## **Exhibition – Vopak Bulk Liquids Storage Facility, Port Botany (MP 06\_0089 MOD 2)**

Review of MP 06\_0089 MOD 2 – Vopak Site B Capacity Increase (Arriscar Pty Ltd)

# Review of MP 06\_0089 MOD 2

## Vopak Site B Capacity Increase

**Figure 11.** FN Curve for all DG movements on Denison St

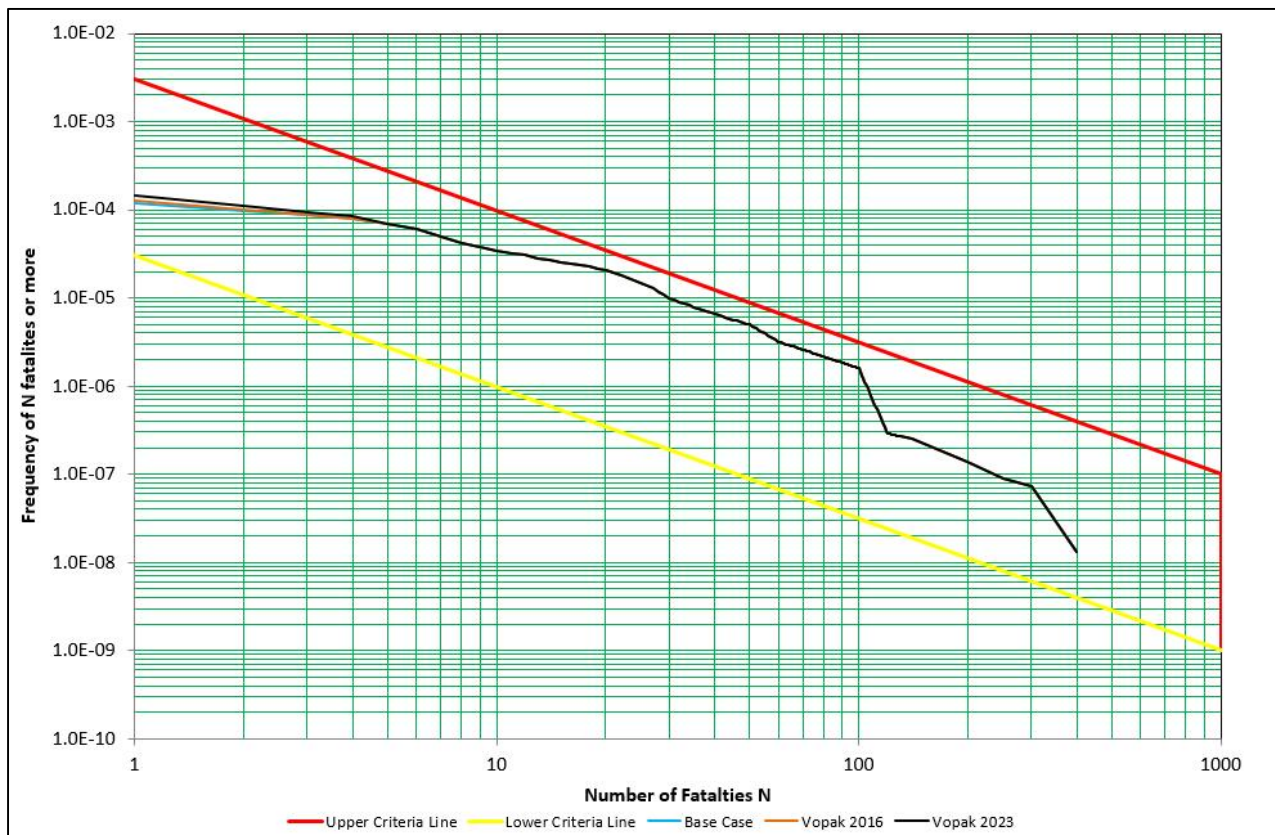
Accordingly, Arriscar recommends that the proponent confirm if the cumulative effect of both fixed installations and Dangerous Goods Transport was considered in Appendix F and provide the information if it has been omitted. This will enable Council to review its own planning scheme near Denison Street based upon the total risk in the area.

Table 1 lists the captions from F-N curves submitted in Appendix F [10]. From the captions of each figure, it is unclear if the contribution of risk from nearby fixed facilities such as the Botany Industrial Park (BIP) has been included in these results. As such, the EA has not addressed item 7.2.4 c) from the Review of Planning Controls [1] .
